Our Case Number: ABP-314597-22

Re: BusConnects Galway Cross-City Link Scheme.  
University Road to Dublin Road, Galway City.

**Re Case No. 314597 Bus Connects Galway Cross City Link**

Role	Transport Infrastructure
Suitability	Planning
Arup Job No	253352-00
Name	BCG-GA-00-02
Rev	PL01

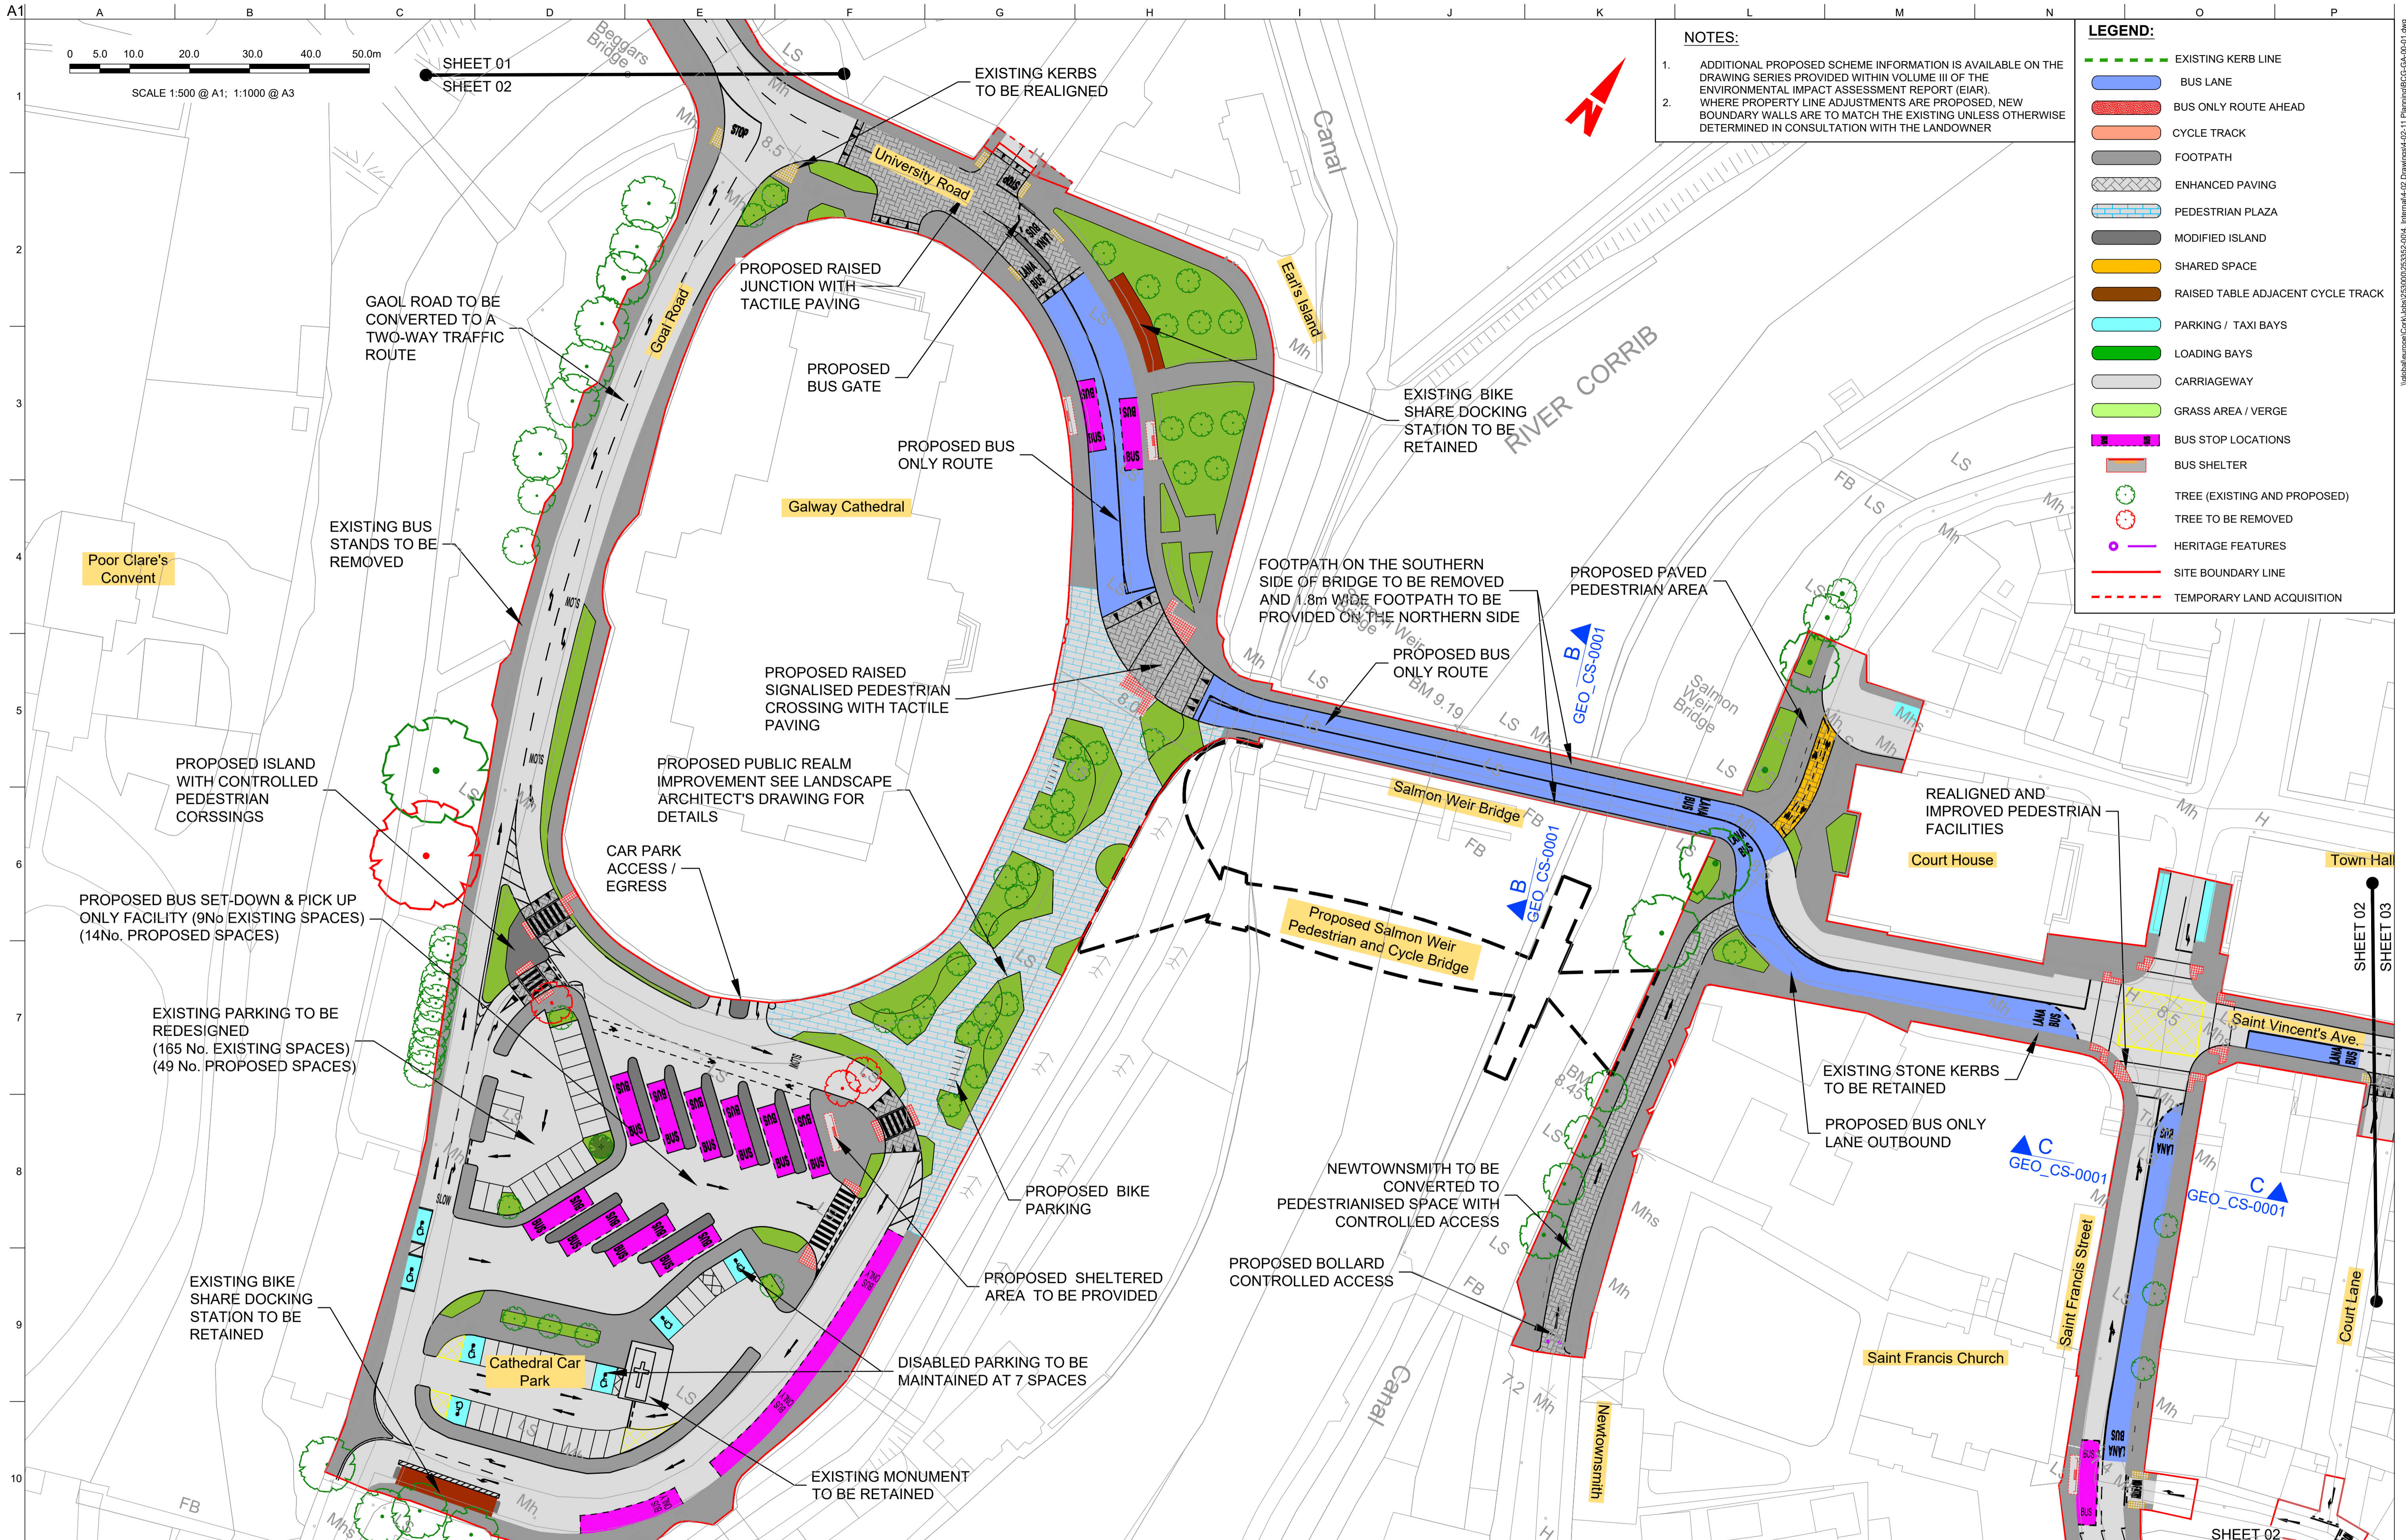
**116 at the Cathedral** General Arrangement Drawings Sheet 2 of 3, in the above document and
